Kirklees Council
Planning and Development Service
PO Box 1720
Huddersfield
HD1 9EL

**Application for Approval of Details Reserved by Condition
Town and Country Planning Act 1990
Planning (Listed Buildings and Conservation Areas) Act 1990**

Discharge of conditions 3 (construction management), 4 (temporary drainage), 5 (temporary waste arrangements), 7 (adoptable roads), 12 (waste storage and collection), 13 (tree protection), 14 (units 23 and 24 revisions), 16 (detailed drainage scheme), 17 (phase II report), 18 (remediation strategy), 23 (materials) and 31 (vegetation removal) of previous permission 2019/91657 for erection of 30 dwellings

Land at Station Road, Skelmanthorpe, Huddersfield, HD8 9BA

PHASE 1 - SCALE 1:500

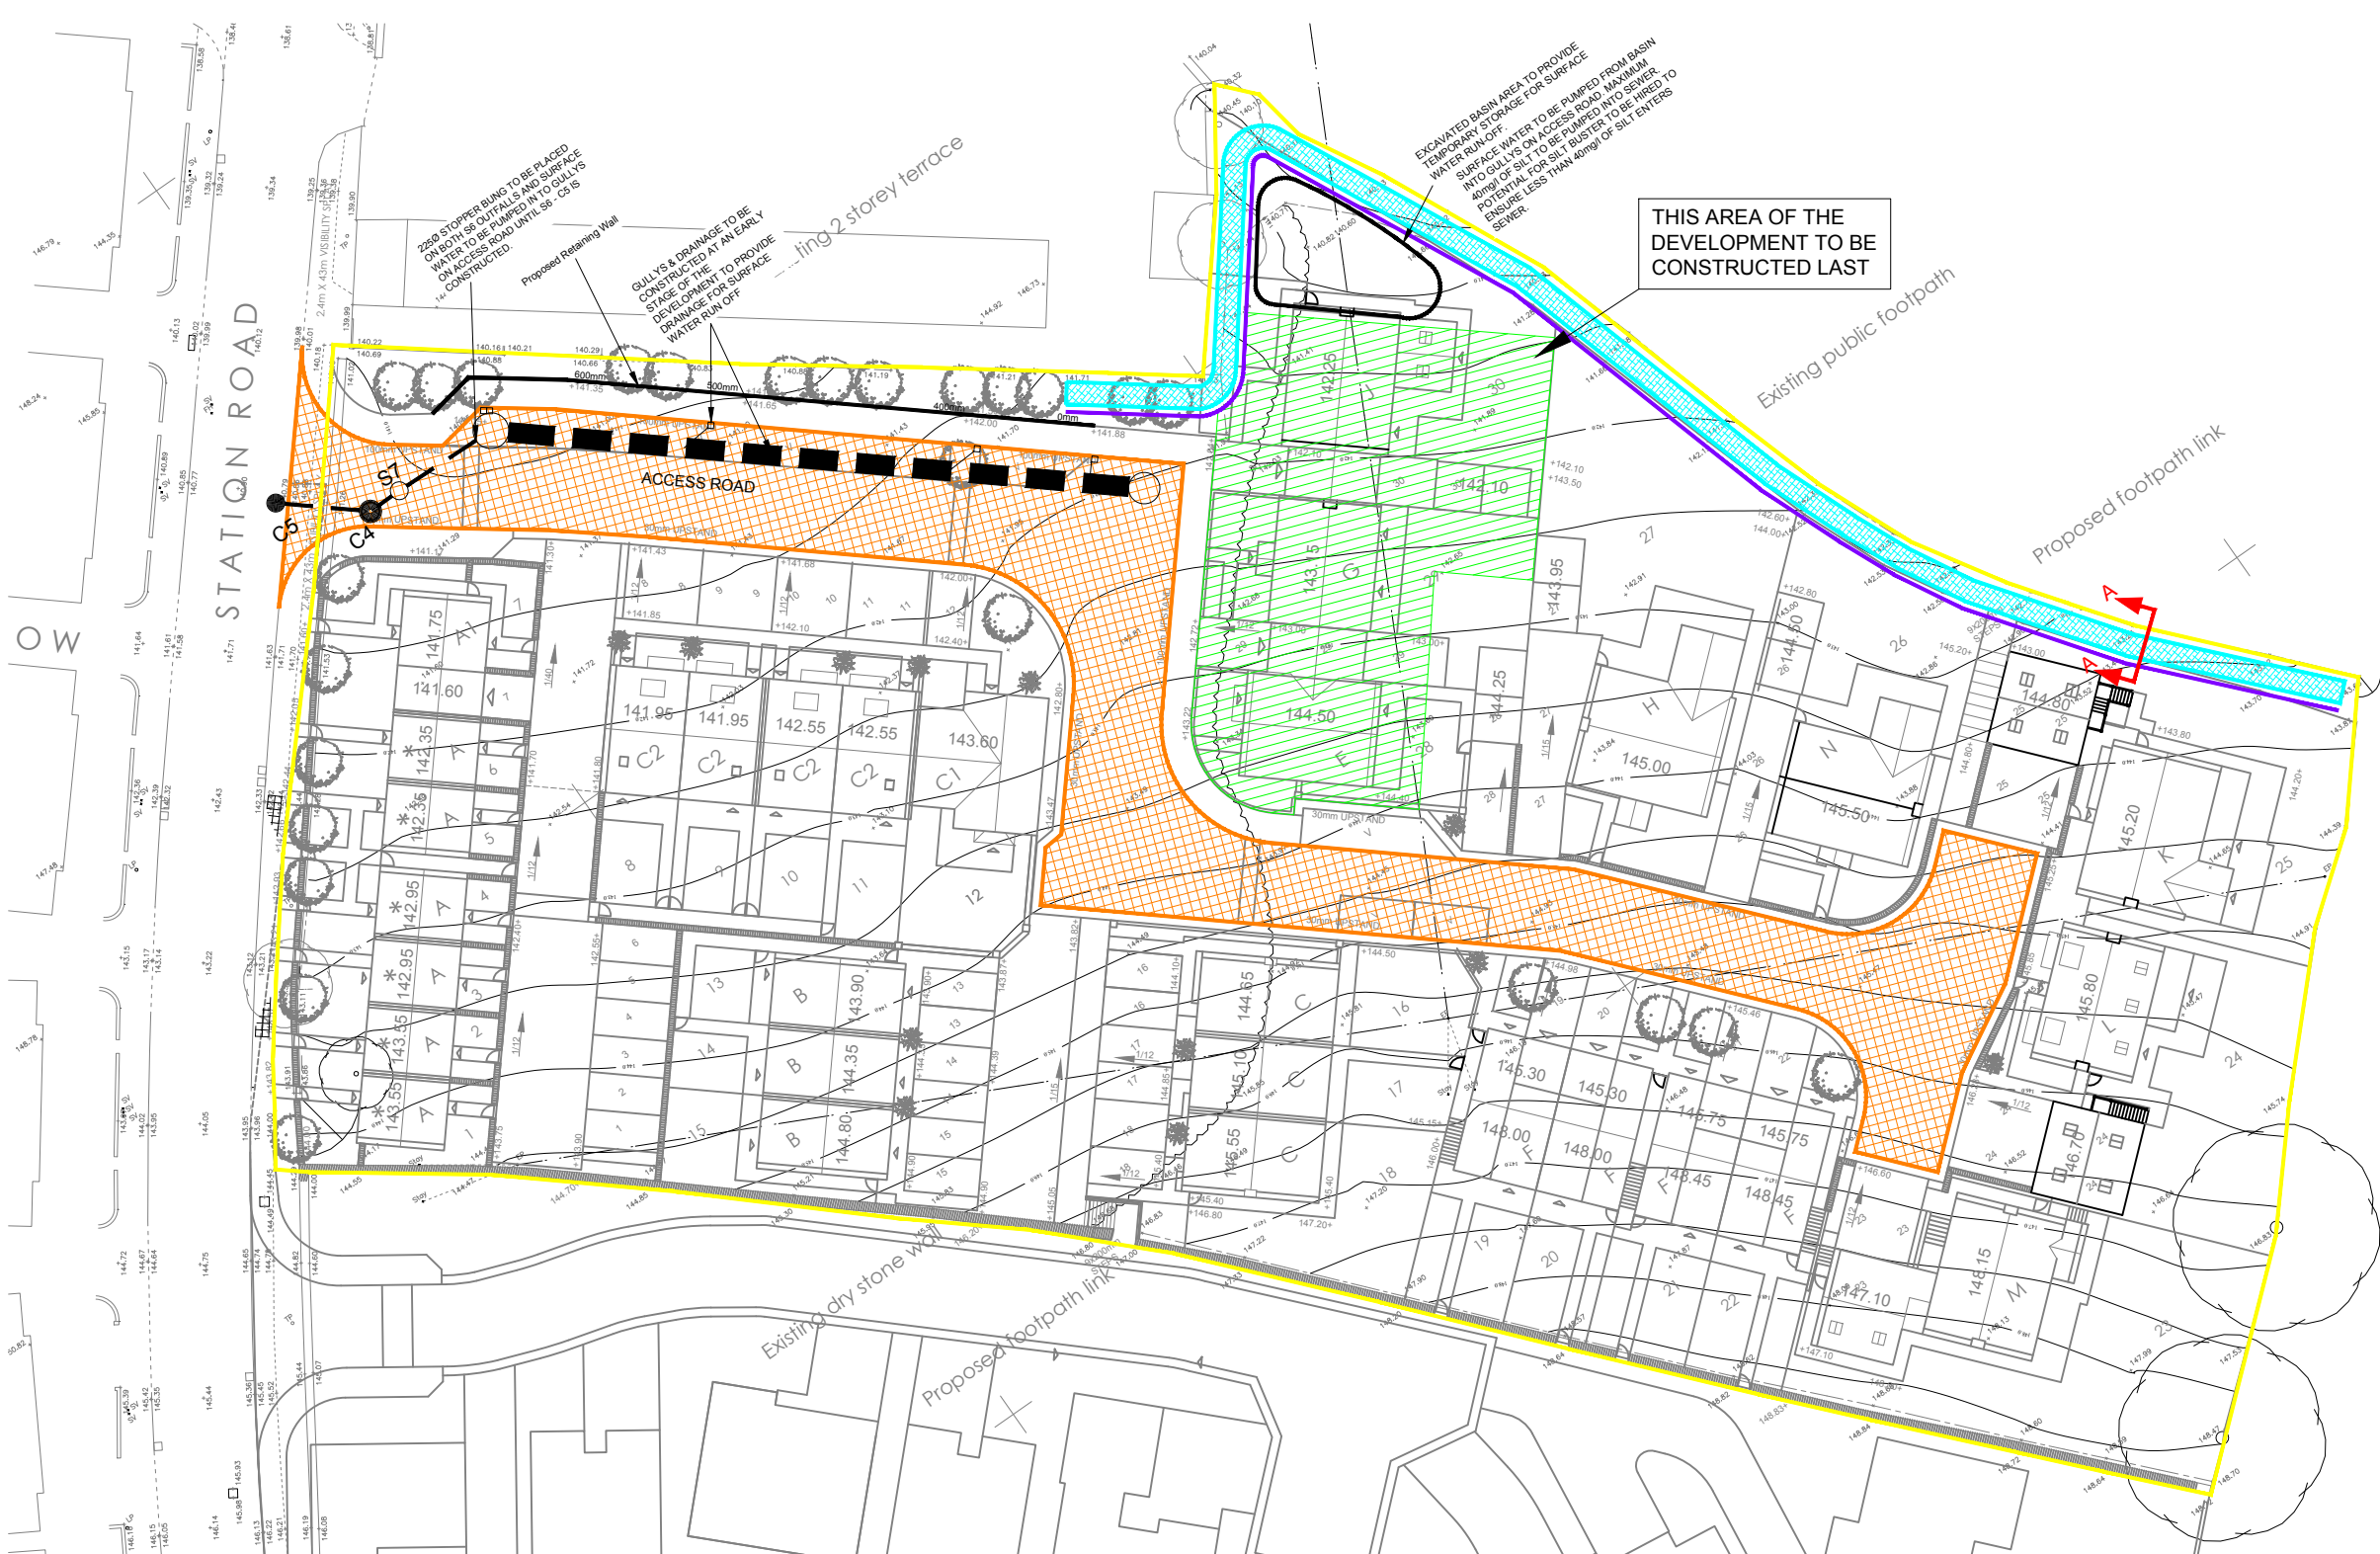
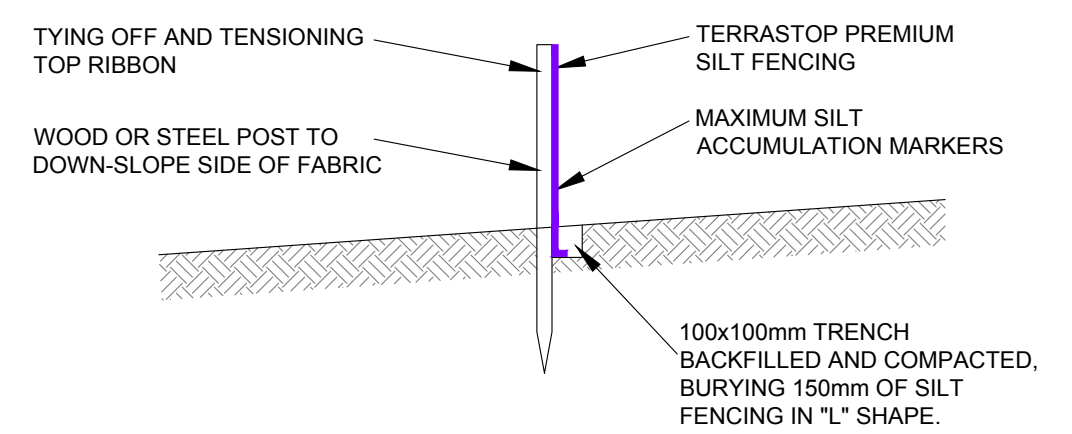
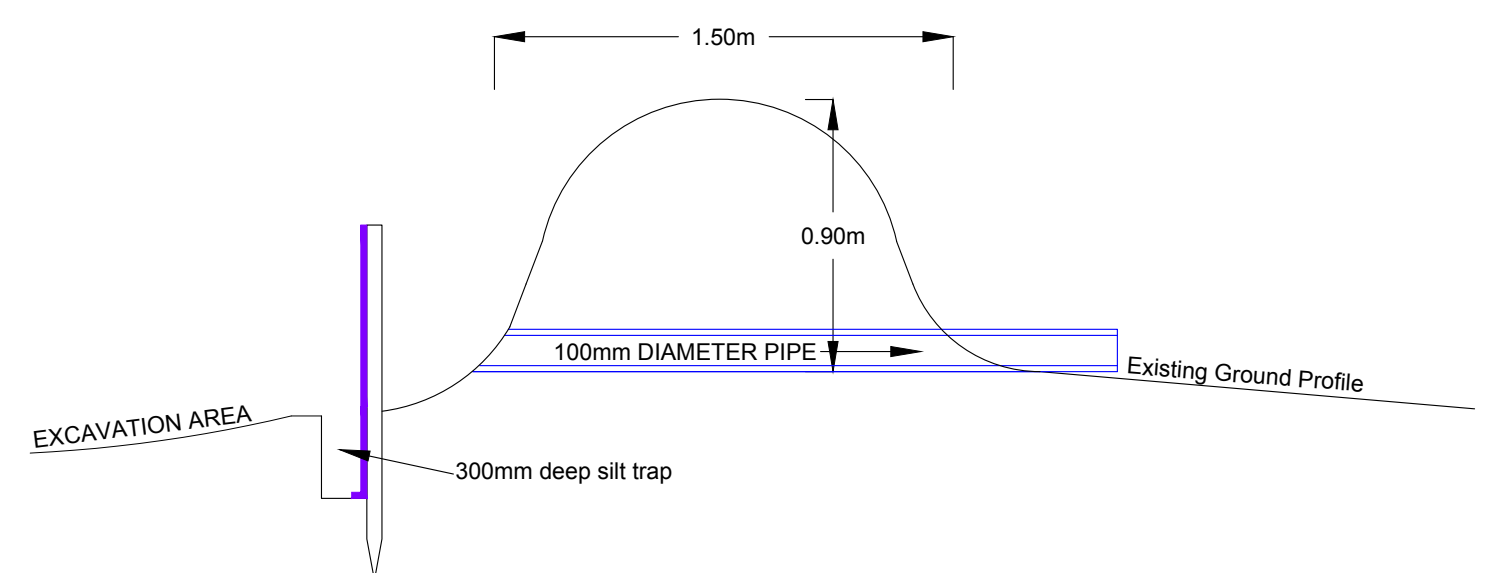
Condition 4 (temporary drainage) – You have submitted a Surface Water Management Plan (drawing E18/7366/042B), a risk assessment (Haigh Huddleston, E18/7366/MH006, 09/08/2021), and a Construction Management Plan (rev B, 01/12/2022). On 02/12/2022 you confirmed (by email, with photographs) that two witches hats had been installed in Station Road.

Details set out in the above-listed documents, drawing, email and photographs are considered acceptable for the purpose of condition 4, and are hereby approved.
